DEPARTMENT OF THE ARMY
WILMINGTON DISTRICT, CORPS OF ENGINEERS
69 DARLINGTON AVENUE
WILMINGTON, NORTH CAROLINA 28403-1343

Action ID. SAW-2017-02112 NC DOT TIP No.: Winston-Salem Northern Beltway in Forsyth County, TIPs R-2247 (Western Section), U-2579 AA and AB, the Winston-Salem Northern Beltway (Eastern Section of Future I-74), from US 311 to I-40

Reference is also made to your July 19, 2024, request to make modifications to this project. Specifically, a request for permit modification associated with Site #3 for U-2579 AB to permanently place 18 linear feet (lf) of rock streambank stabilization in an area previously authorized for 12 lf of temporary impact. In addition, you requested a permit modification for U-2579 AA, Sites #12A, #12B, and Stormwater Plan revision found on Stormwater Plan Sheets 5 and 6.

- **Sheets 1 of 5, labelled by the Corps, “SAW-2017-02112 NCDOT U-2579 AB Winston-Salem Northern Beltway Site #3 Modification Forsyth Co., N.C.” and dated August 27, 2024.**
- **Sheets 2-3 of 5, labelled by the Corps, “SAW-2017-02112 NCDOT U-2579 AA Winston-Salem Northern Beltway Site #12A & #12B Modification Forsyth Co., N.C.” and dated August 27, 2024.**
- **Sheets 4-5 of

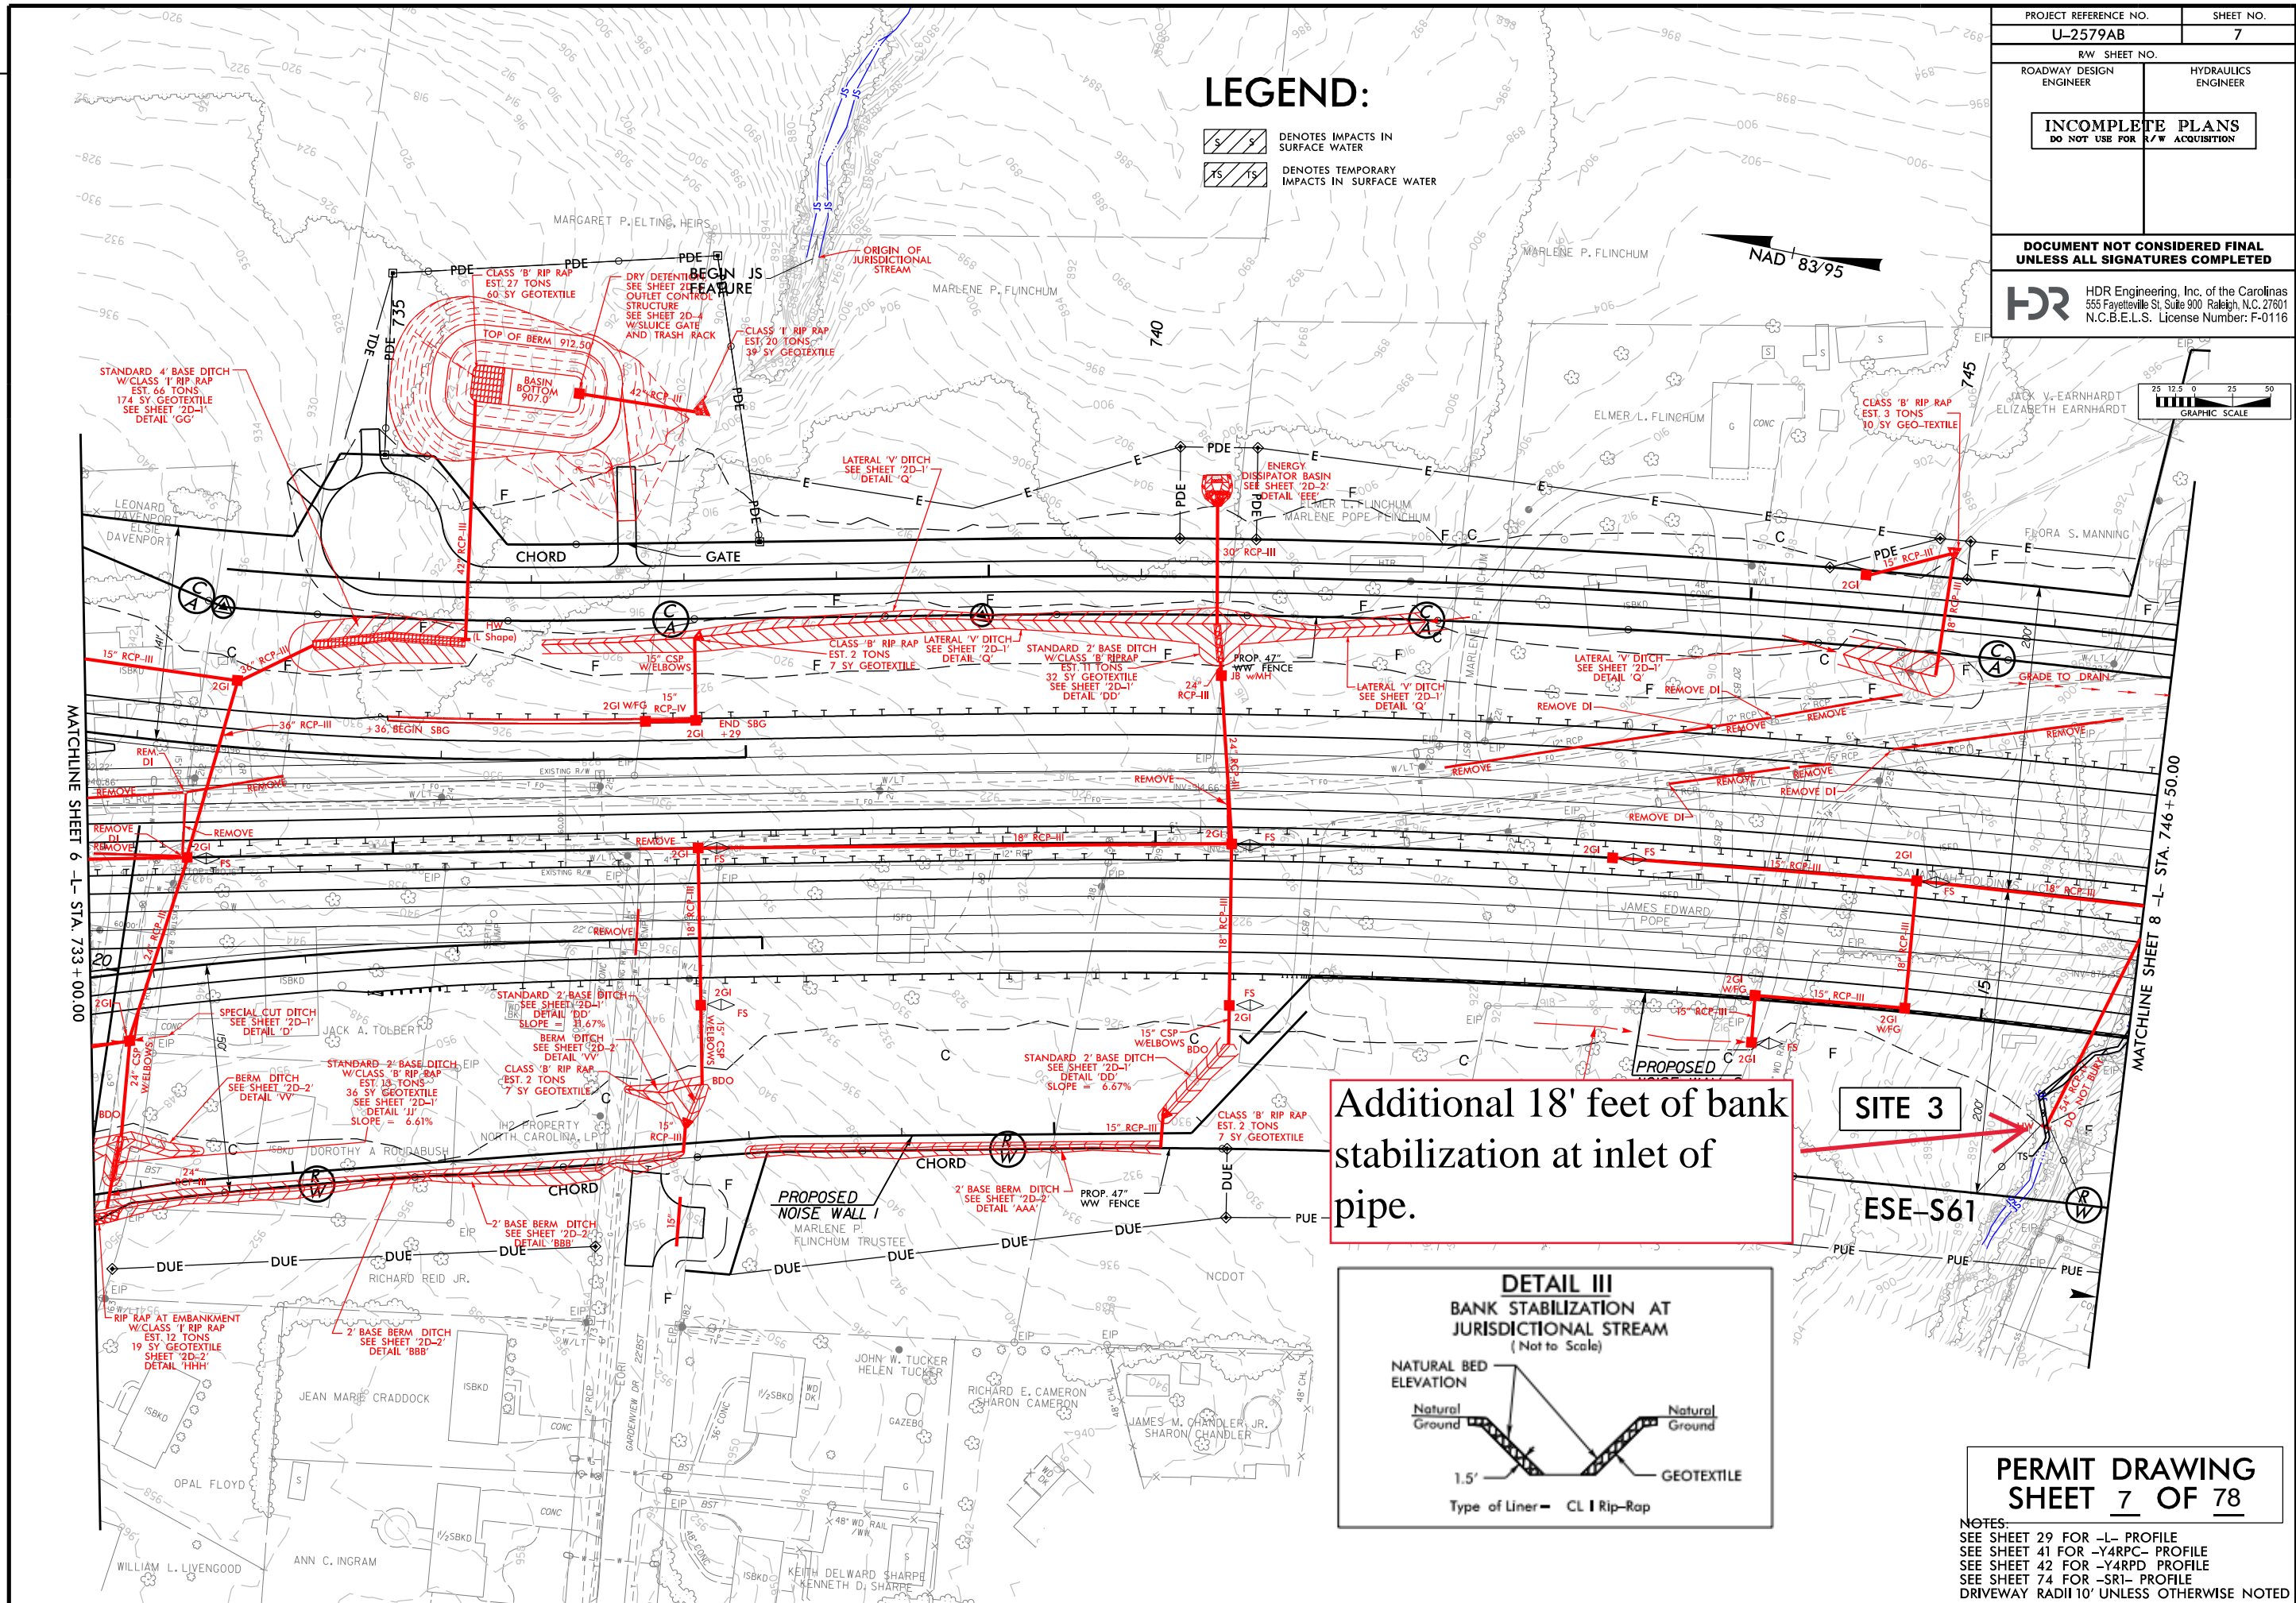
These modifications would include an increase in total permanent stream impact of an additional 18 linear feet (lf) beyond what was authorized, however most of this change is within an area previously authorized for temporary impacts from dewatering activities. This addition permanent impact will include placement of stream bank stabilization in this 18 lf segment that will not result in a loss of waters and therefore do not require compensatory mitigation. The proposed modifications for U-2579 AA are related to plan changes and do not result in any changes to previously authorized impacts to waters. These have been included to update the plans to include accurate depictions of NCDOT's construction and structures for U-2579 AA & U-2579 AB.

The permittee shall ensure that the construction design plans for this project do not deviate from the permit plans, previously modified plans and the specific modified permit drawings attached:
